From: Holly Duncan
Sent: Friday, January 18, 2013 2:28 PM
To: Jeff Watson
Subject: RE: BL-12-00036 Bull

[BL-12-00036 Bull](#)

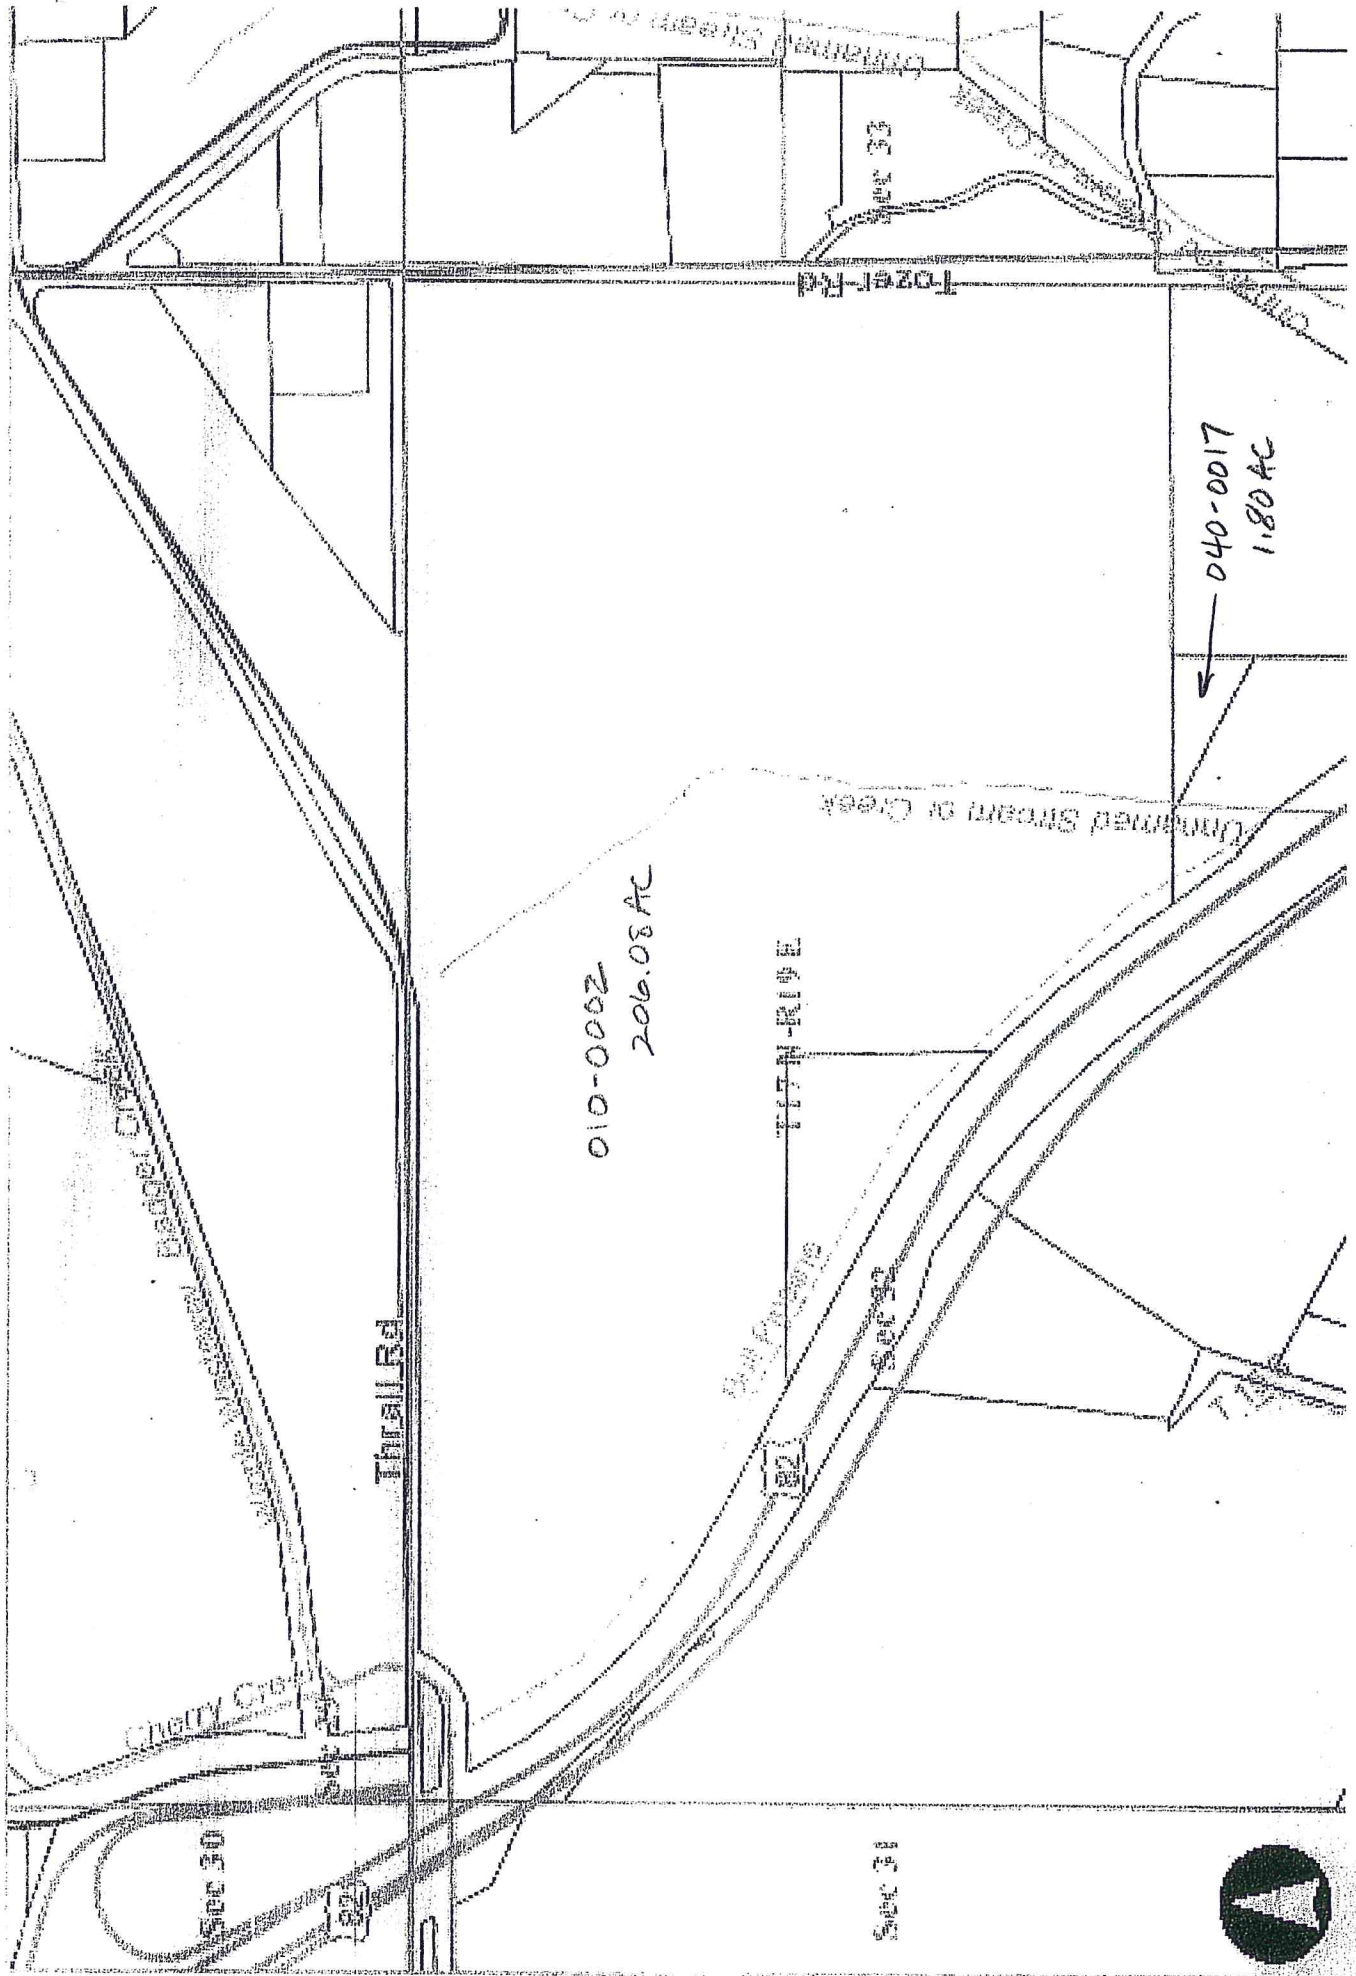
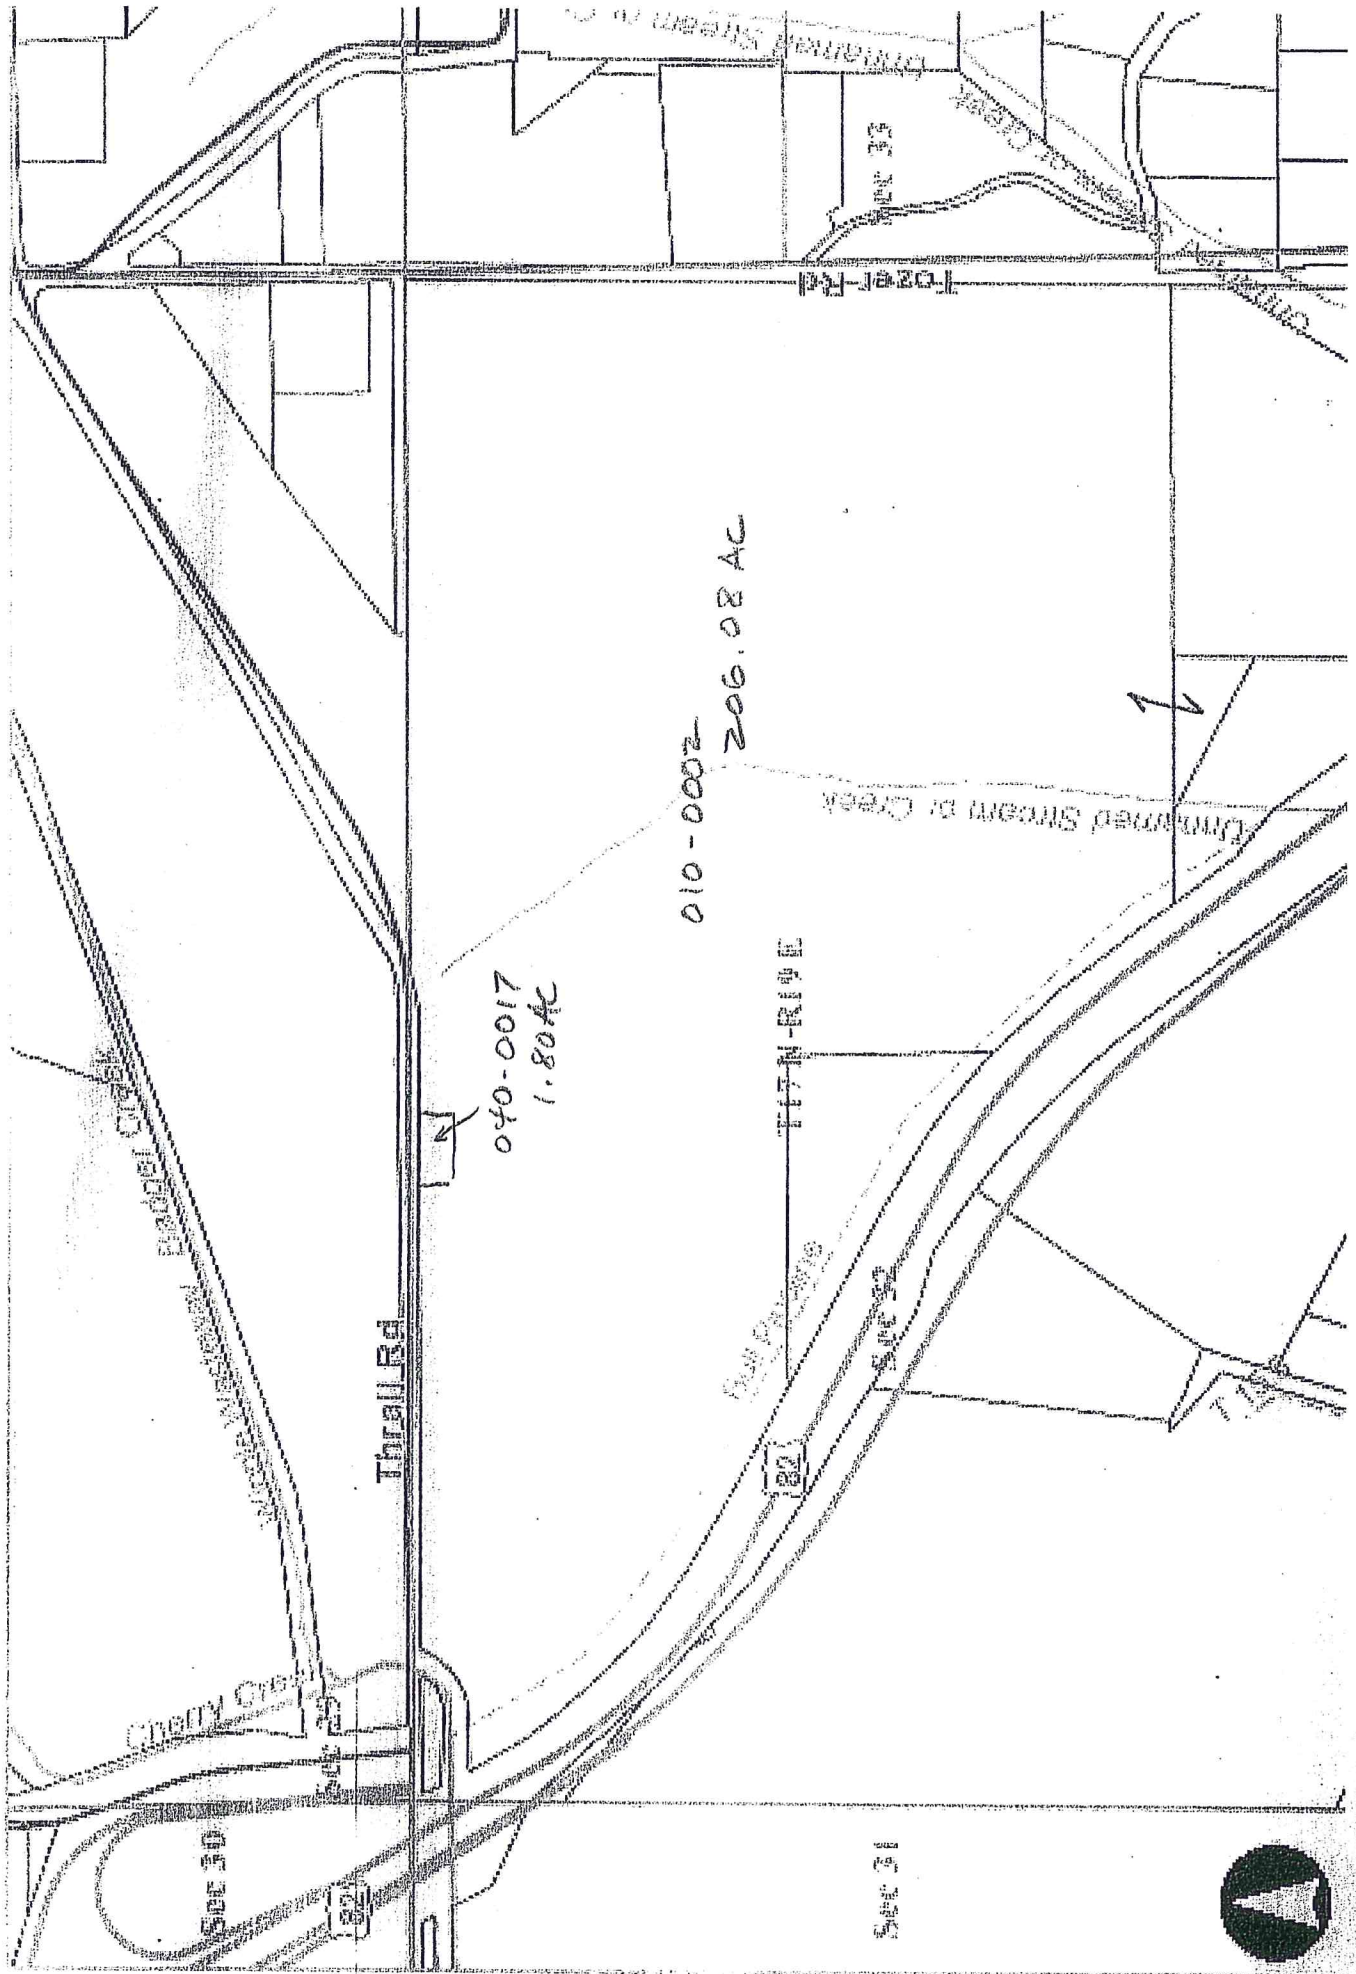
I am curious where the existing well and drainfield are on the proposed 1.8 acre lot. All required setbacks must be met.
